**WINE COUNTRY DRIVE (MR220): HUNTLEE NEW TOWN STAGE 1 PROJECT
APPLICATION EXHIBITION**

I refer to your letters dated 15 March 2011 (Your reference: Huntlee New Town Stage 1 Subdivision) and your email of 16 March 2011 regarding the subject project application, referred to the Roads and Traffic Authority (RTA) for comment. I also refer to the RTA's response to the State Significant Site exhibition dated 29 October 2010.

Appendix 3 Preliminary Wine Country Drive Details

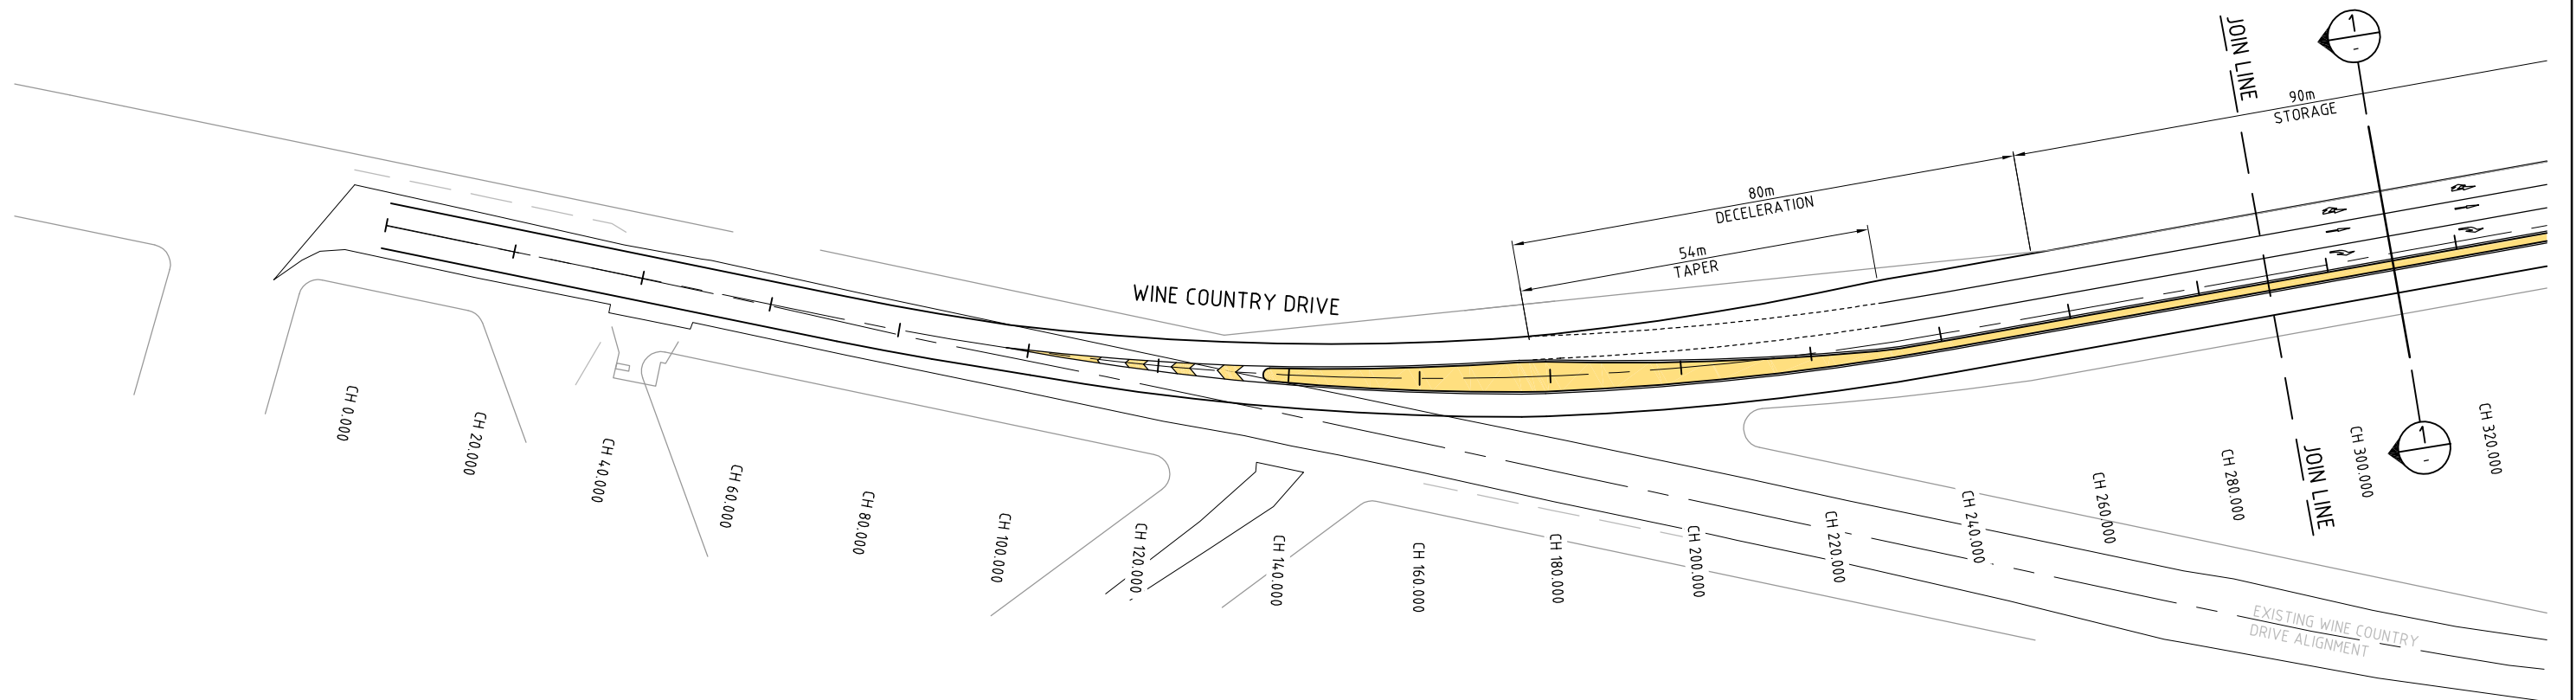
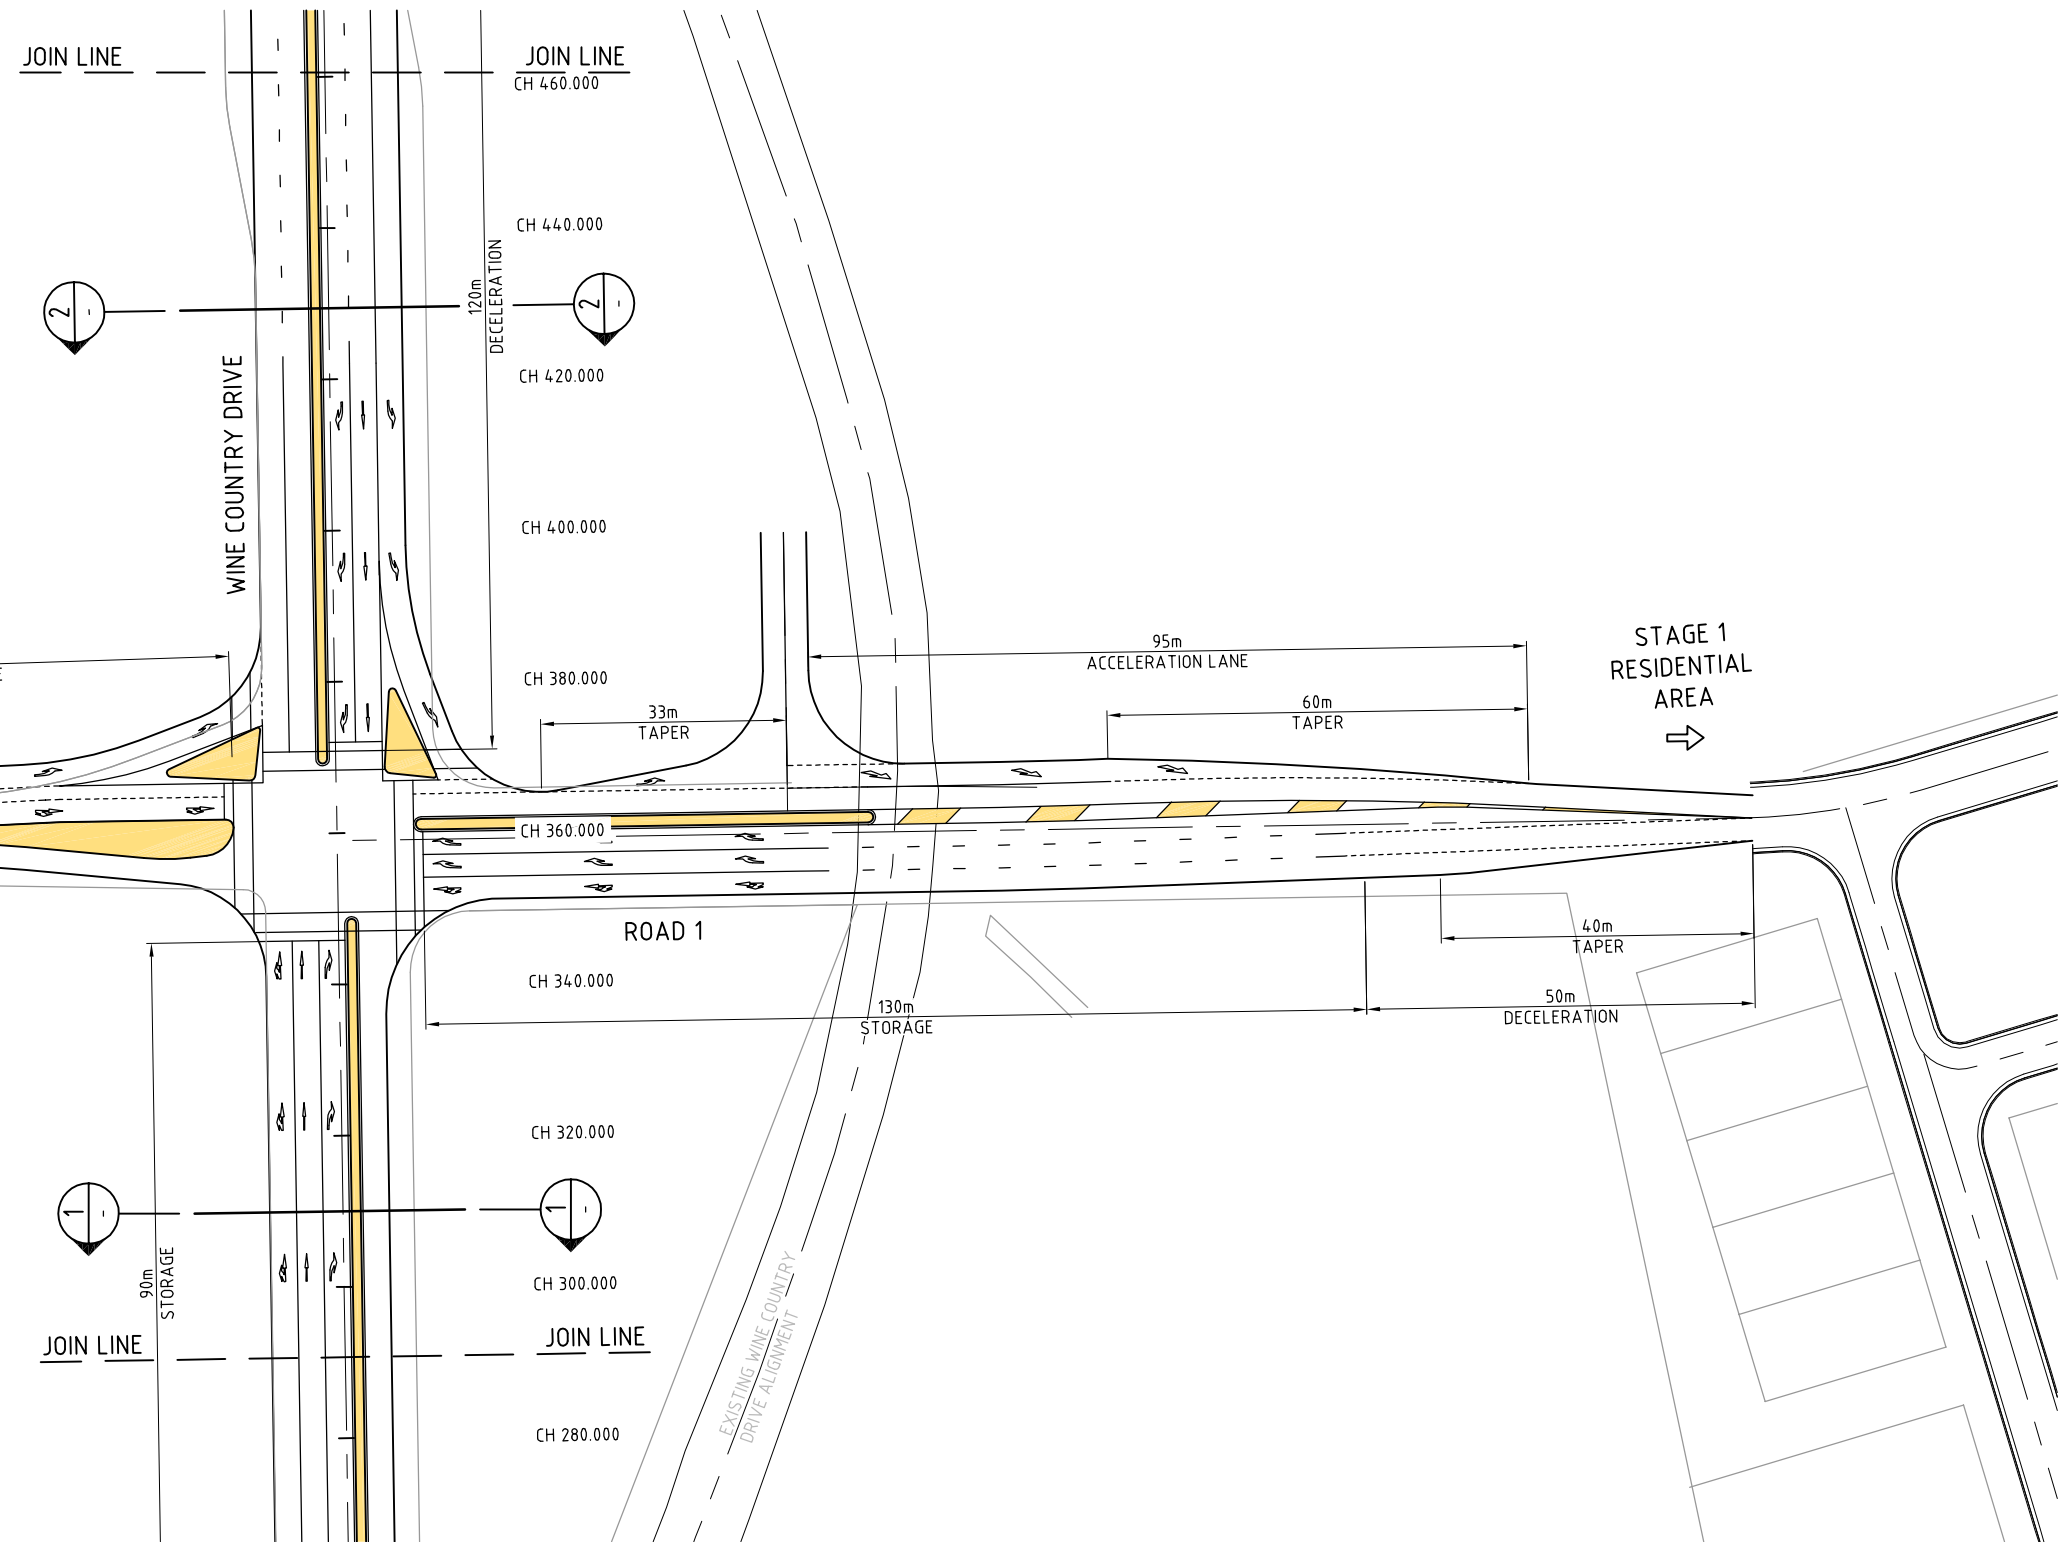
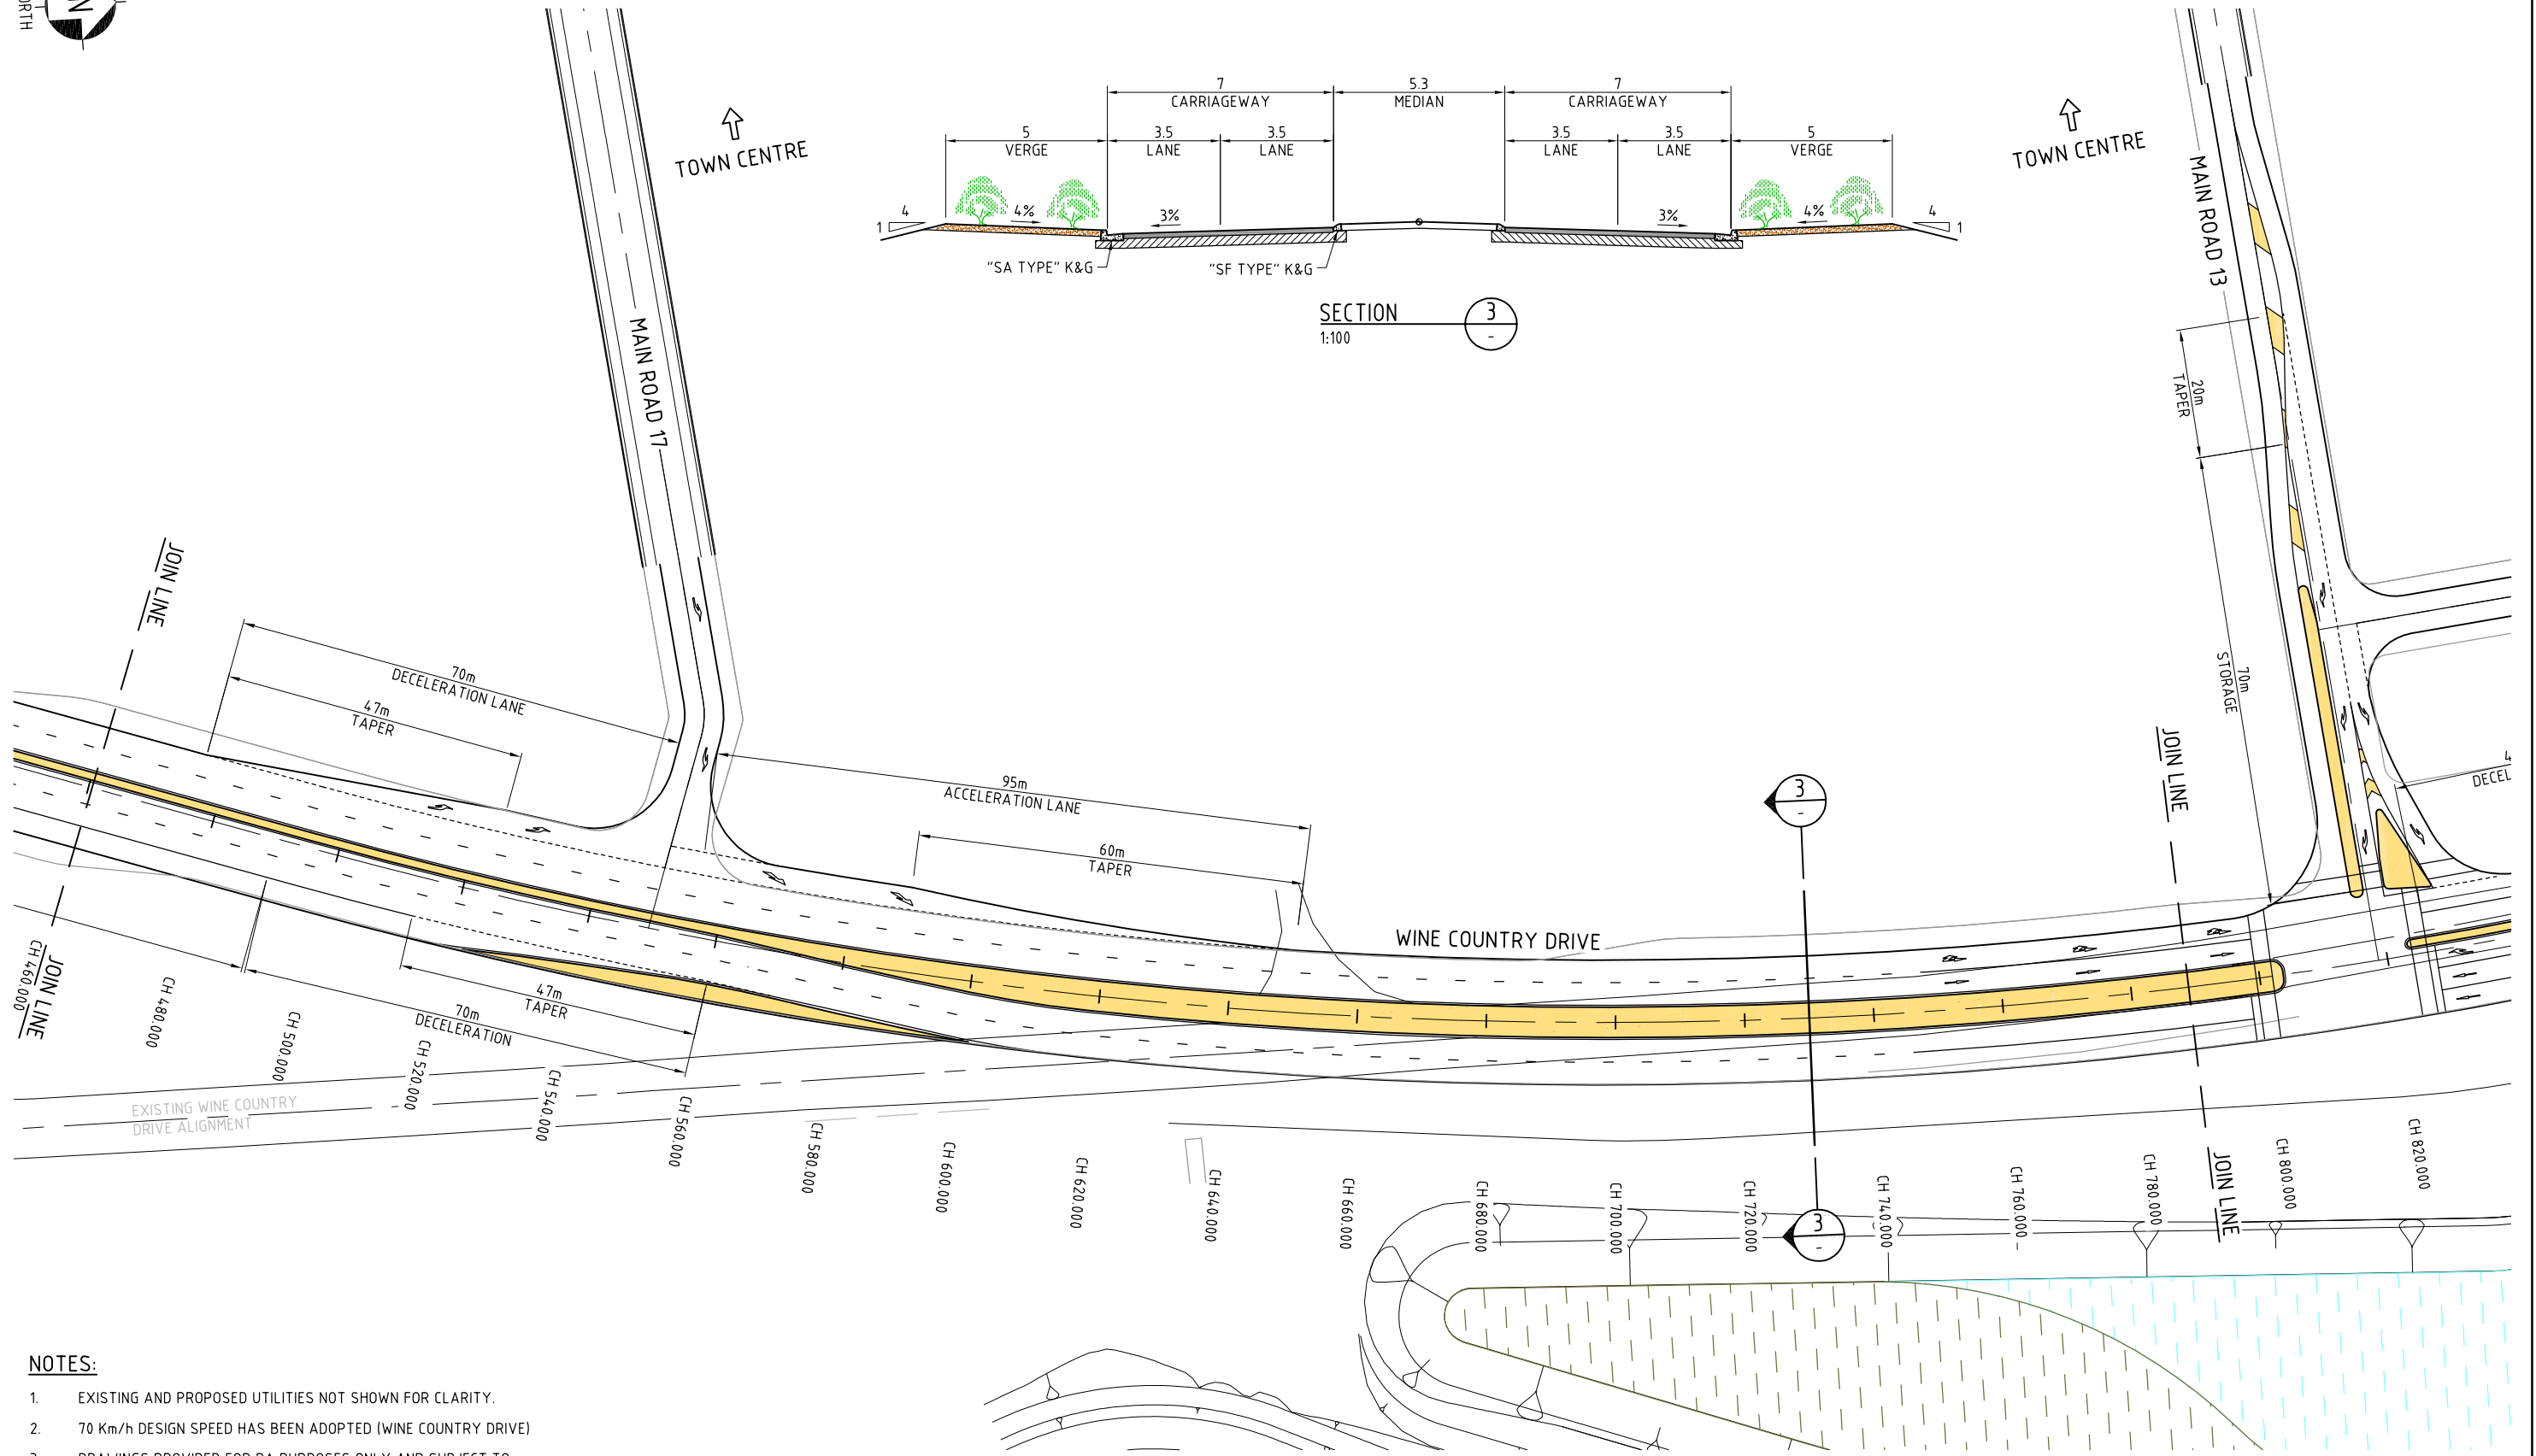
- There is significant conflicting information regarding the number, type and staging of accesses / intersections to the site for Stage I and the full development. This information shall be reviewed and a consistent proposal regarding access / intersections to the development shall be provided. Strategic concept plans of all proposed accesses intersections connecting to the State road network shall be submitted to the RTA for review.

- Preliminary concept plans of any works proposed in connecting to or on State roads shall be provided for RTA review and acceptance.
- There appears to be no vehicular access to the proposed recreational facility on the corner of Wine Country Drive and the Hunter Expressway link road. Concerns are raised about potential parking and congestion issues on State roads due to its current location. It is recommended the facility is relocated to a more appropriate site.

- Given the deficiencies listed above, a review of the strategic concept designs submitted has not been completed. As a minimum, it is expected that the principles of the RTA's *Growth Centres Road Framework* are incorporated into the design of the proposed development. Also, all strategic concept designs shall comply with the requirements of the Austroads *Guide to Road Design* (plus RTA supplements) and the RTA's *Traffic Signal Design*.
